Your Reference: TR030003
**Our Planning Inspectorate
Reference:** 20010091
Our Internal Reference:
DCO/2017/00001

**RE: TILBURY2 – SECTION 89 AND THE INFRASTRUCTURE PLANNING
(EXAMINATION RPROCEDURE) RULES 2010: EXAMINING AUTHORITY’S “RULE 8
LETTER”**

The Marine Management Organisation (MMO) has reviewed the Examining Authority’s (ExA) ‘Rule 8 Letter’ dated 26 February 2018 and the following constitutes the MMOs formal response to deadline 2 as set out in this letter.

REVISED LIMITS OF DREDGING PLAN
TILBURY 2 DOCUMENT REF: POTLL/T2/EX/45

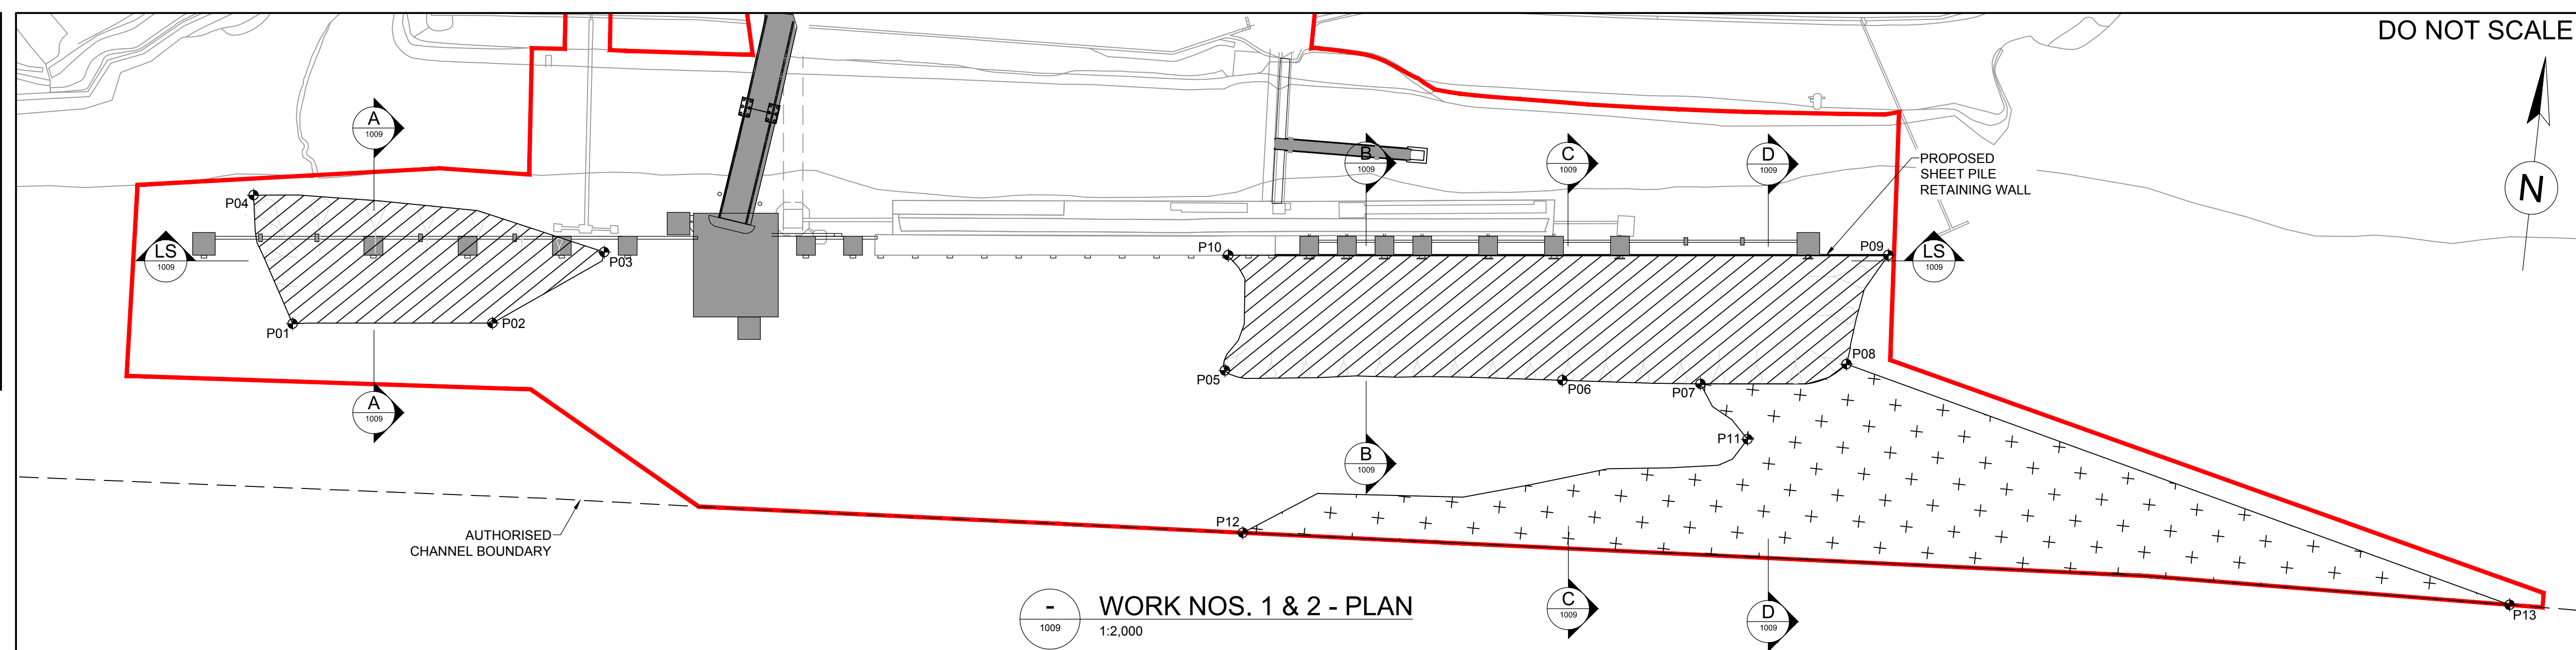
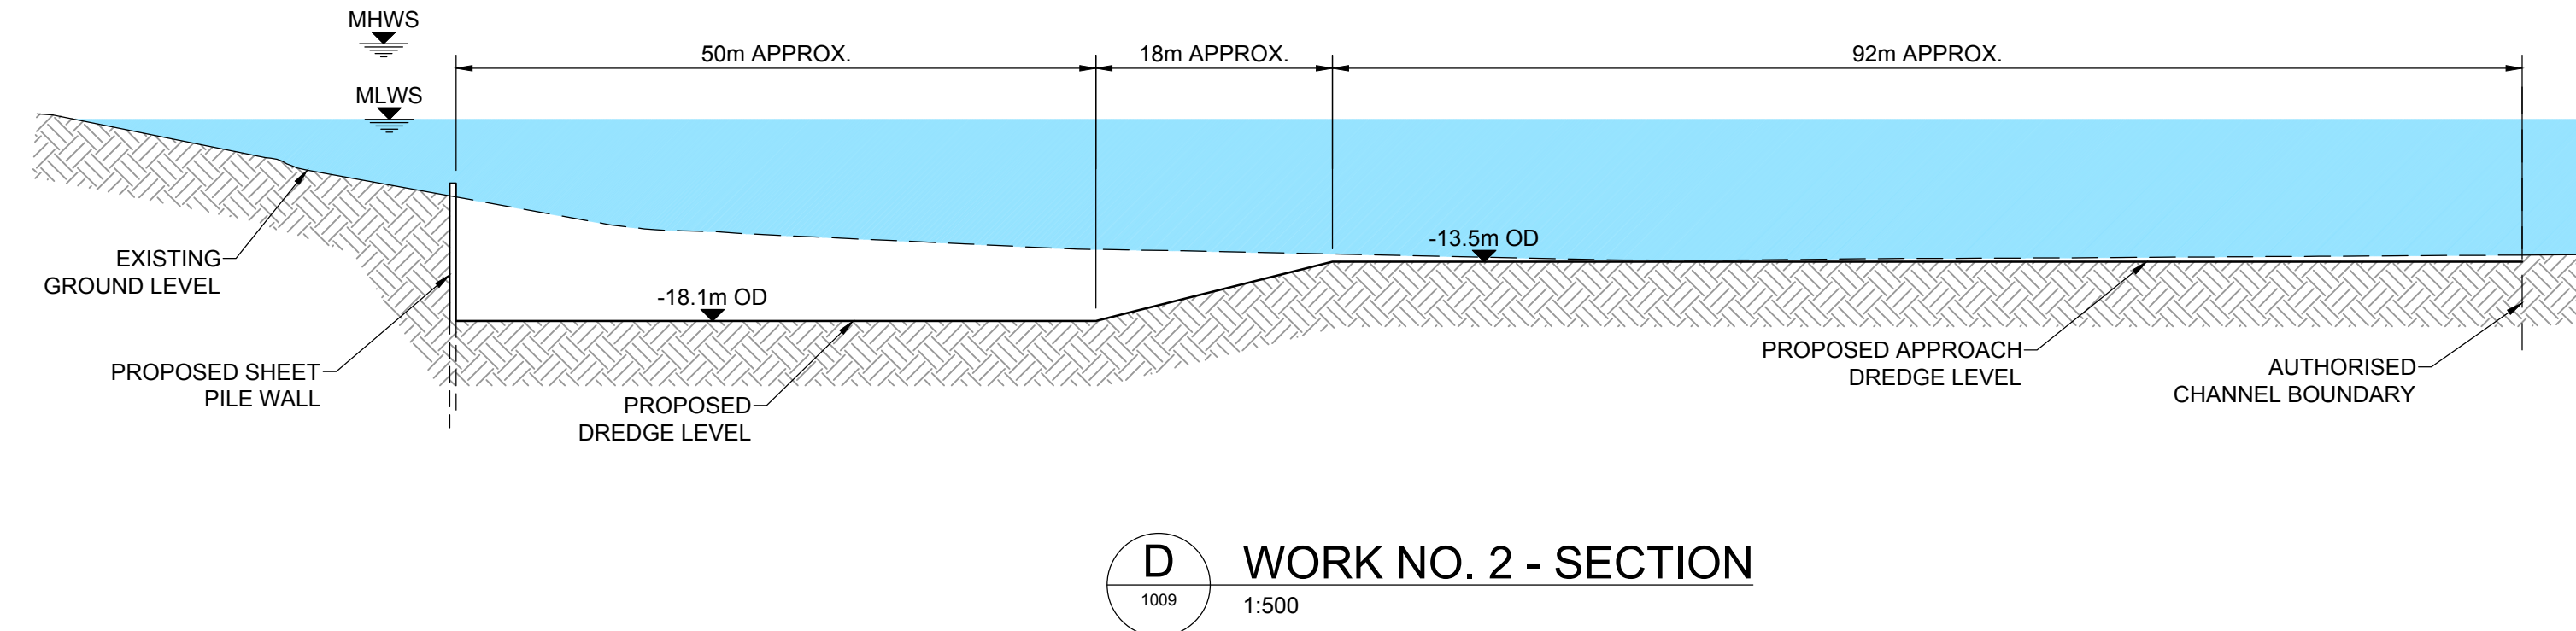
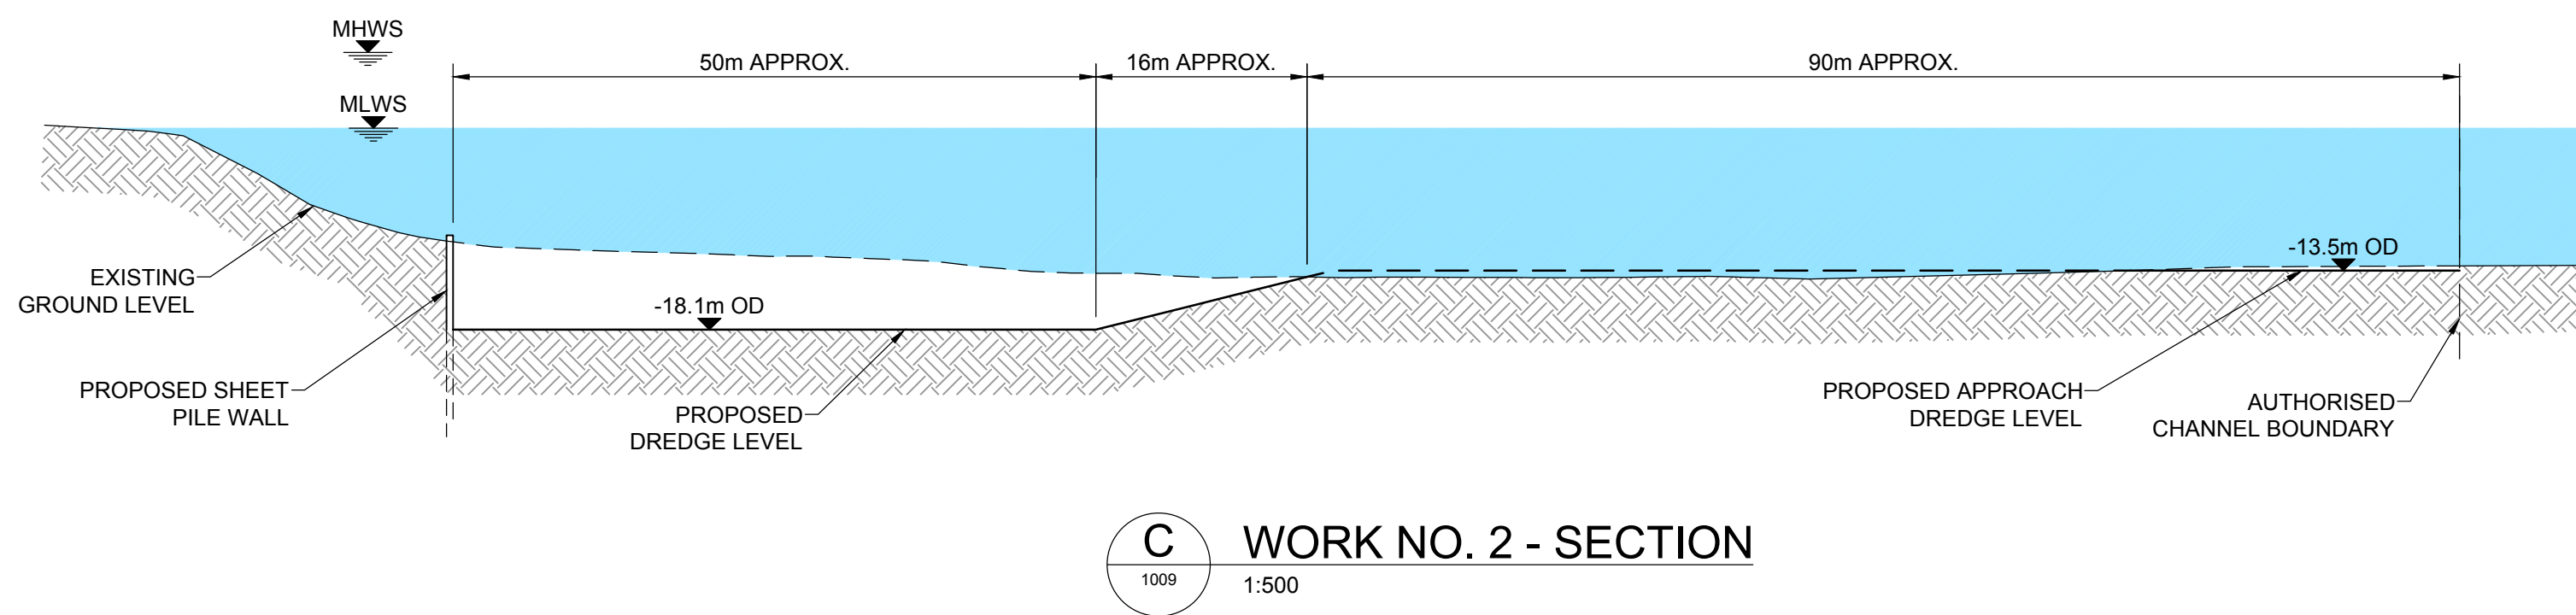
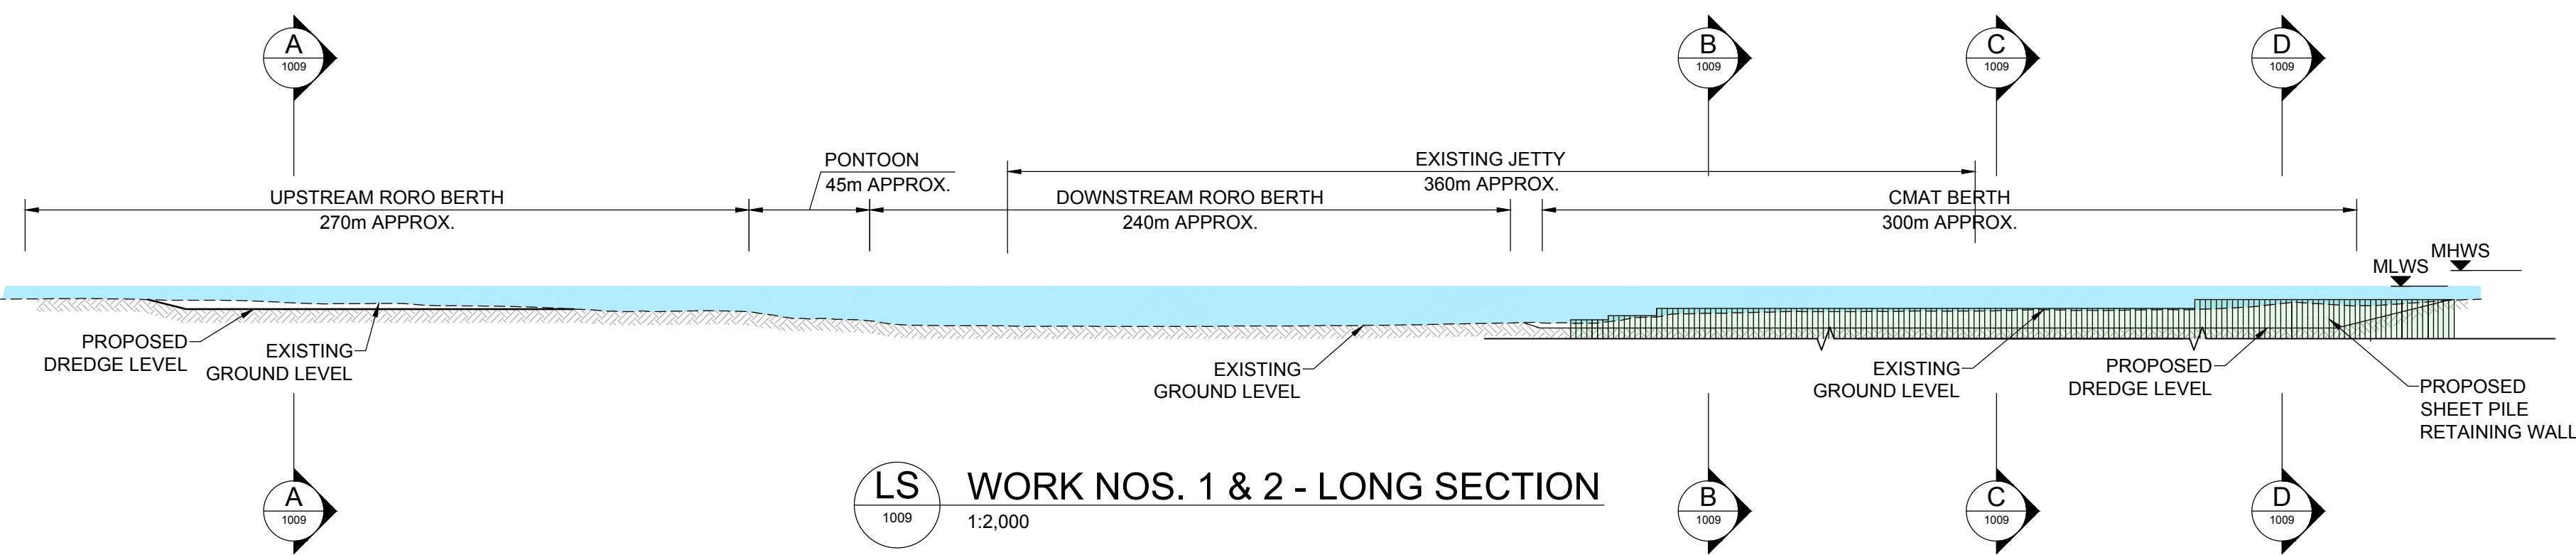
1.1.3. The MMO also agree with section 9.2 of the PLA response regarding dredging maximum depths. This depth should be given as the deepest most limit with respect to the sampling already undertaken. If this maximum depth exceeds that described in the recent sampling, further sampling will be required.

- 4.1.9. FWQ 1.9.11**
- 4.1.9.1. The MMO note that the Applicant has stated that the DCO allows for capital dredging anywhere within the Order Limits however it should be noted that this is restricted by the Limits of Dredging Plan (POTLL/T2/EX/45).

5.2. As stated in section 1.1.3 of this letter, the MMO would expect to see the limits of dredging plan referred to under Limits of Deviation as having maximum depths rather than approximate depths.

REVISED SHEET 3 OF THE WORKS
PLANS

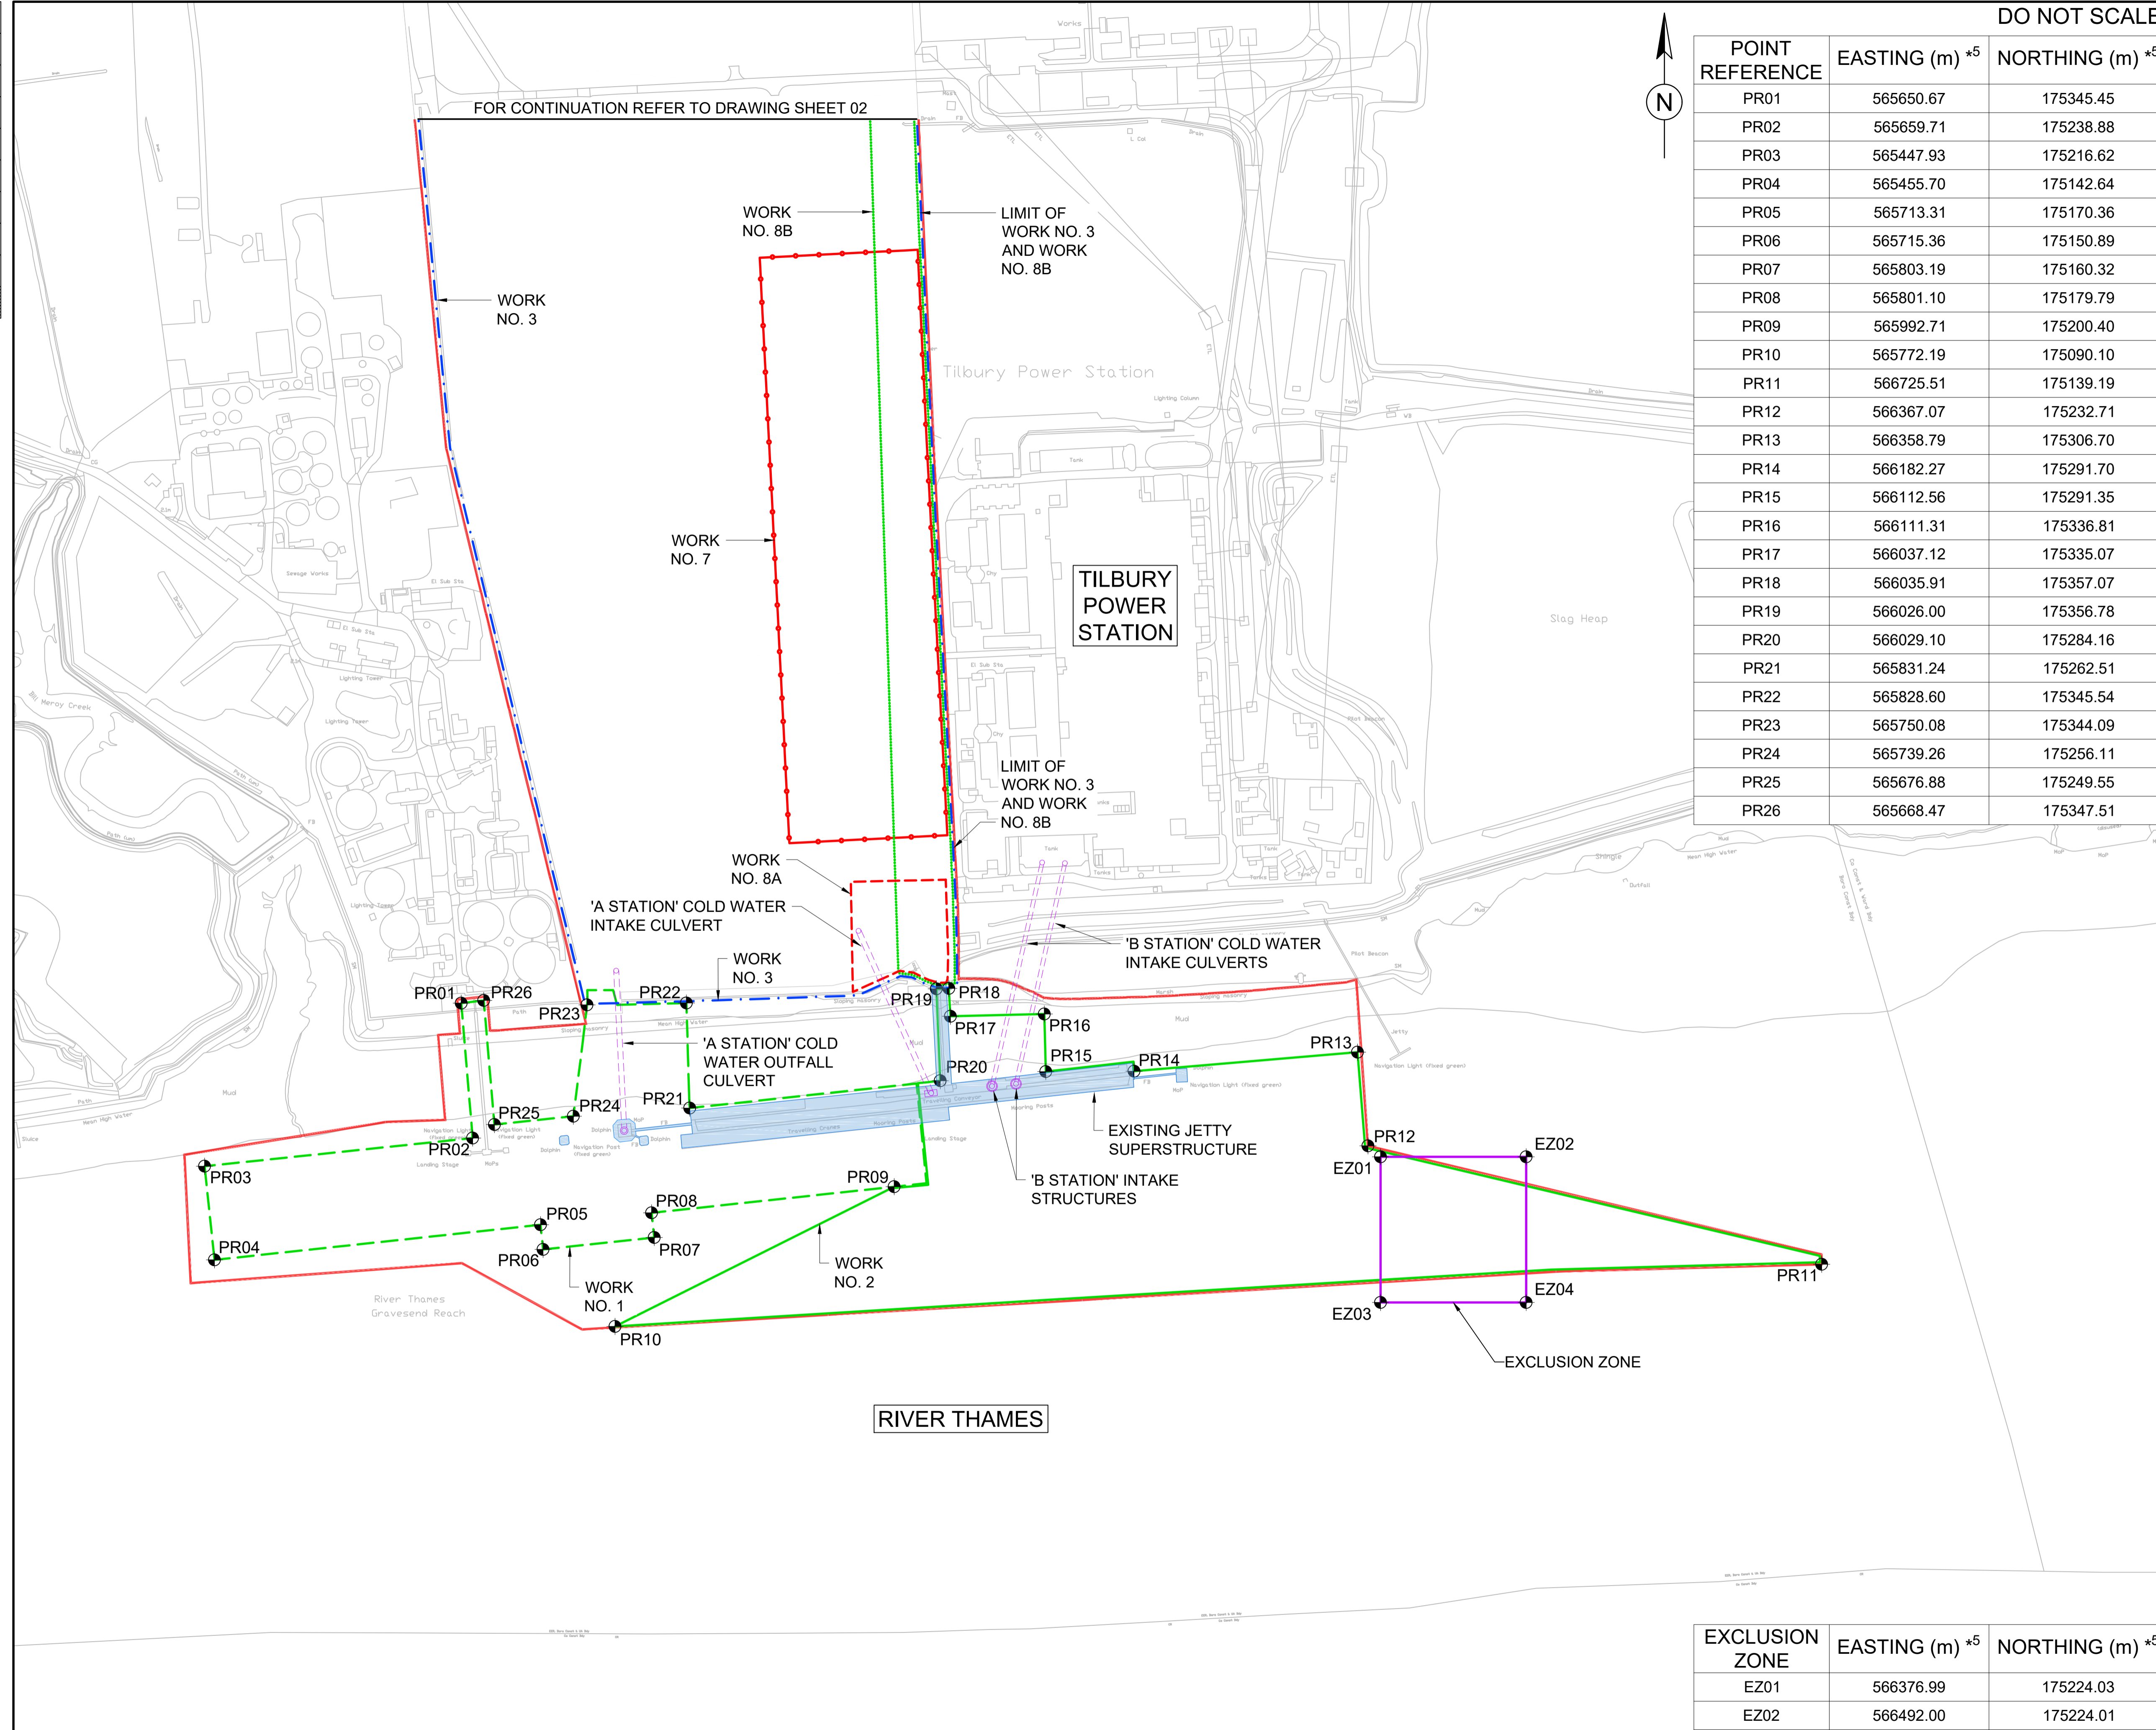
2.1.5.2. The MMO welcome the updated Sheet 3 of the Works Plans to include the dredging exclusion zone. Discussions were held on this matter, as there is an area of the proposed exclusion zone that falls outside the Red Line Boundary. As such, it was requested that the co-ordinates be updated to ensure they aligned with this boundary, the MMO note that this is yet to be done.
